## Department of Transportation

October 10, 2023

RE: Veterans Victory - Developmental Plan Lot 1 {DEPN-23-0002; SUBD-23-0008}

Figure 20  
CDOT/Powers Boulevard Improvements

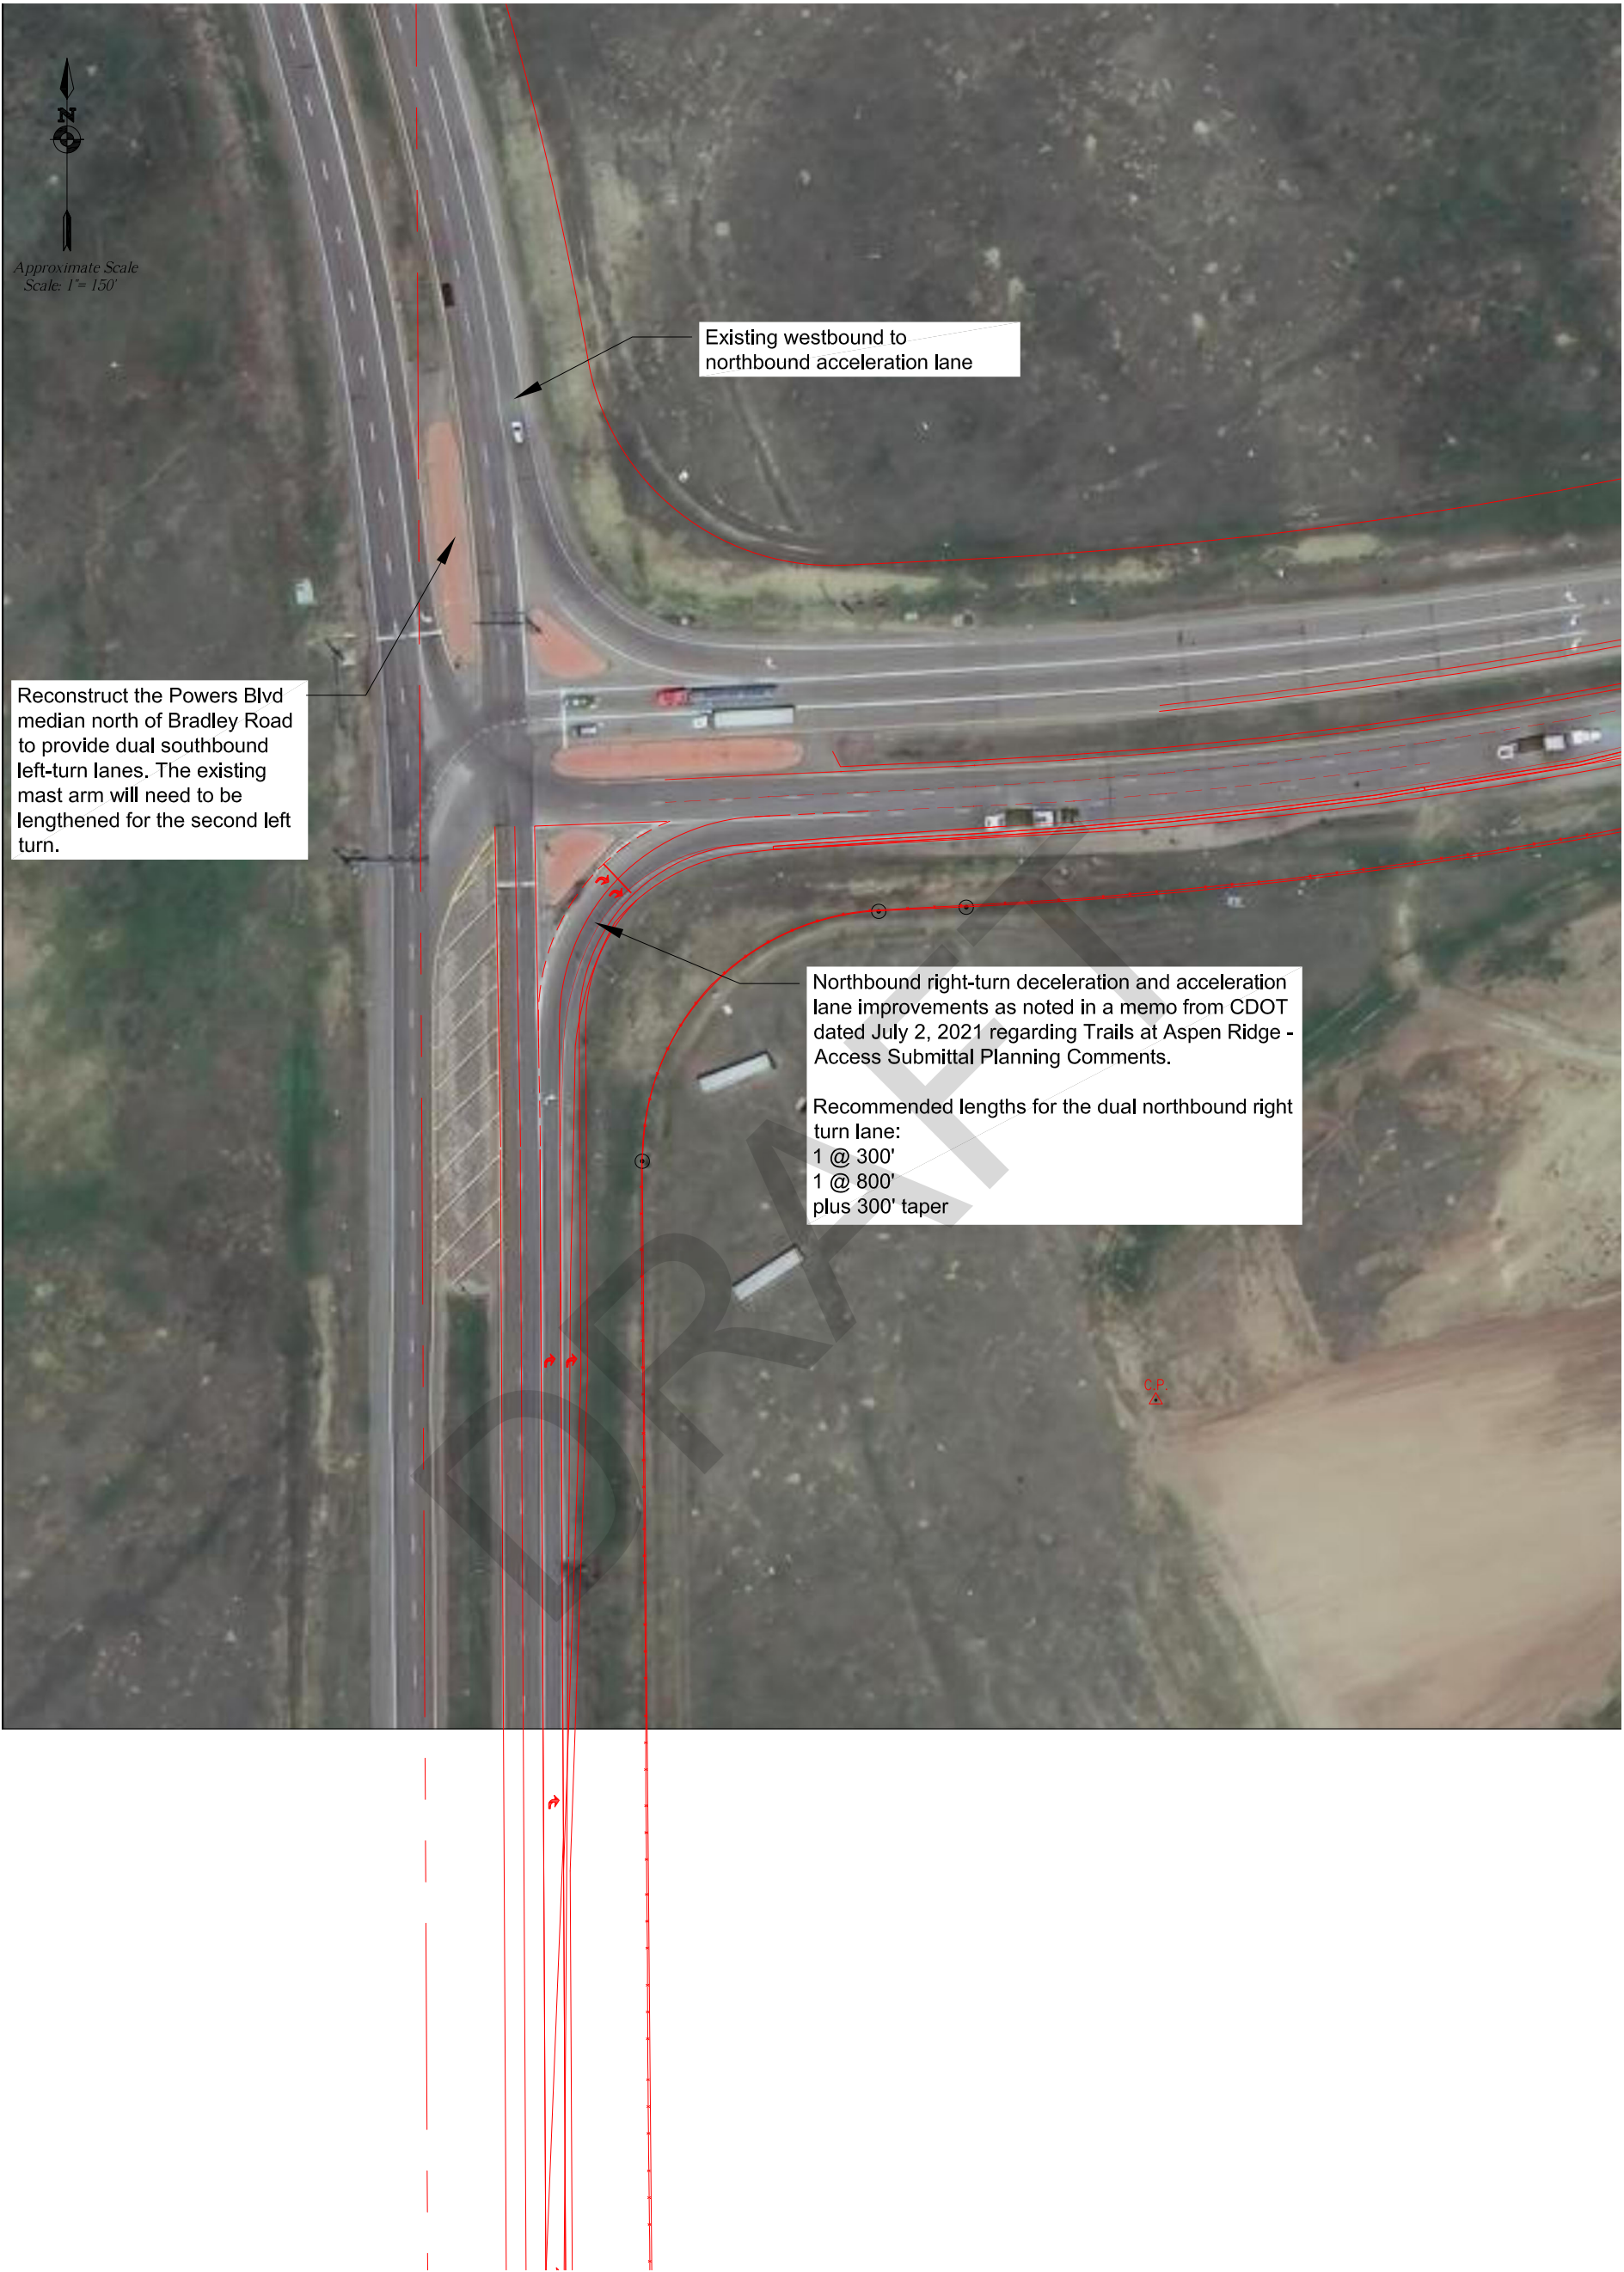
- *The following conditions are a requirement for the Notice to Proceed and are agreed upon in TIS (Table 4):*
  - a) *An additional left turn lane from southbound SH21A/Powers Blvd. to eastbound Bradley Rd. is required to be installed. This requirement creates a southbound dual left traffic movement at the intersection of SH21/Bradley Rd. The construction plans will require adjustment to the existing traffic signal, extending the arm to cover the additional southbound left turn lane. The Development Engineering team will need to confirm that the existing traffic signal pole and caisson can support a longer arm. Otherwise, the entire signal pole will need replaced with the access permit.*
  - b) *An additional right turn lane from northbound SH21/Powers Blvd. to eastbound Bradley Rd. shall be required. This requirement creates a northbound dual right turn*

*traffic movement. Northbound right turning traffic lanes from SH21/Powers Blvd onto eastbound Bradley Rd. shall be signalized controlled. This additional lane requires the roadway widening of this turning movement per the State Highway Access Code.*

- c) The northbound right turn lane along SH21 to eastbound Bradley Rd. shall be extended further south to allow for additional queuing for the dual right turn movement onto eastbound Bradley Rd. from SH21a/Powers Blvd.*
- d) The westbound to northbound free right turn acceleration lane from Bradley Rd. onto SH21/Powers Blvd. shall be extended to the north to allow for additional merging traffic; refer to CDOT access code for proper acceleration lane length and taper.*
- e) A collection of escrow funds shall be required for the developments fair share percentage for future intersection/interchange improvements.*
